Consultation Response KC Landscape

Planning Number:	2024/92339		
Proposal:	Discharge of details reserved by conditions 13 (CEMP), 15 (CEMP-Biodiversity), 27 (Drainage) 33 (Landscaping),		
Location:	Piazza Centre, Princess Alexandra Walk, Huddersfield, HD1 2RS		
DEVELOPER/APPLICANT/AGENT:	Pegasus Planning Group Ltd		
Planning Officer:	Ellie Thornhill		
Date Responded:	05.09.2024	Responding Officer:	Landscape – EM
Site Area (Hectares)		Responding Ref:	NN44

NOTES/COMMENTS:COND 33 – Landscaping

Planting Plan
Sheet 01

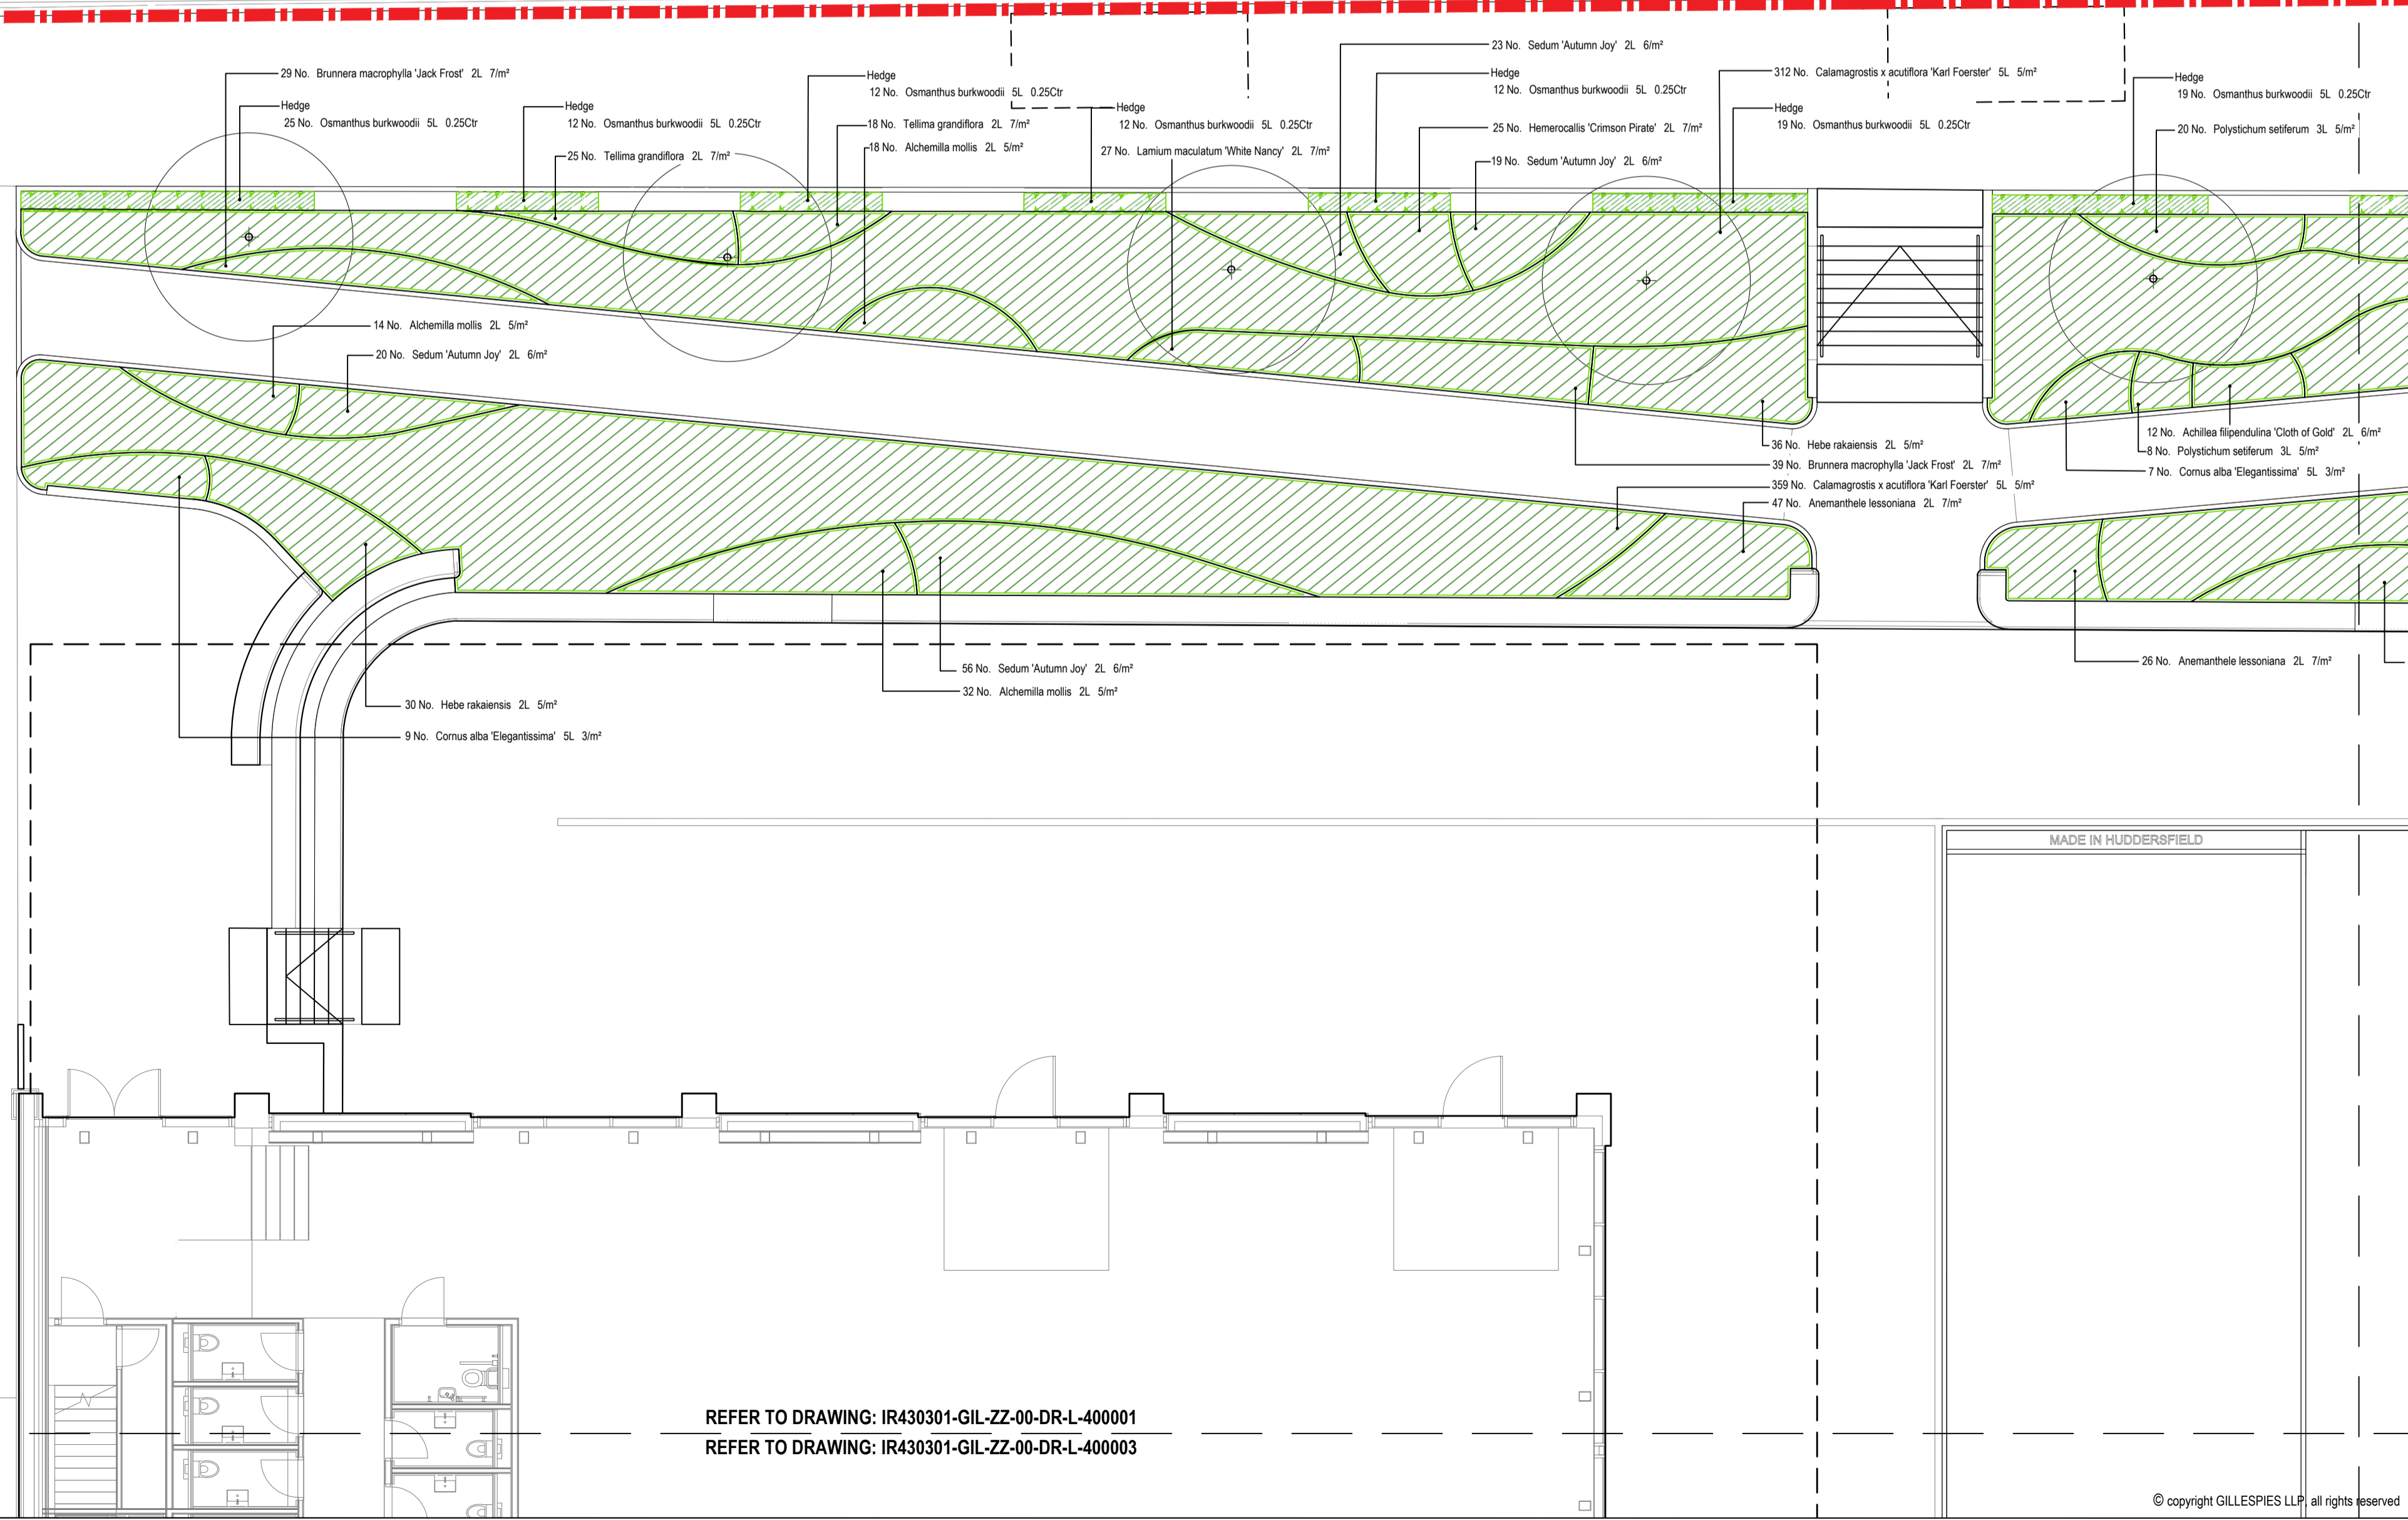
The proposed planting lists include some potentially invasive species, which should not be planted in this setting and should be substituted with more appropriate less invasive species. When submitting detailed landscape proposals, preference is for species which are not potentially invasive and details from Natural England [can be found here](#). [Horizon-scanning for invasive non-native plants in Great Britain - NECR053 \(naturalengland.org.uk\)](#)

There's some further guidance on [NNS on alternative species to use for landscapers here](#). Species selection is important and those which are potentially more invasive should be substituted for less potentially invasive species.

Preference is for native and proven beneficial to pollinators where possible for this location.
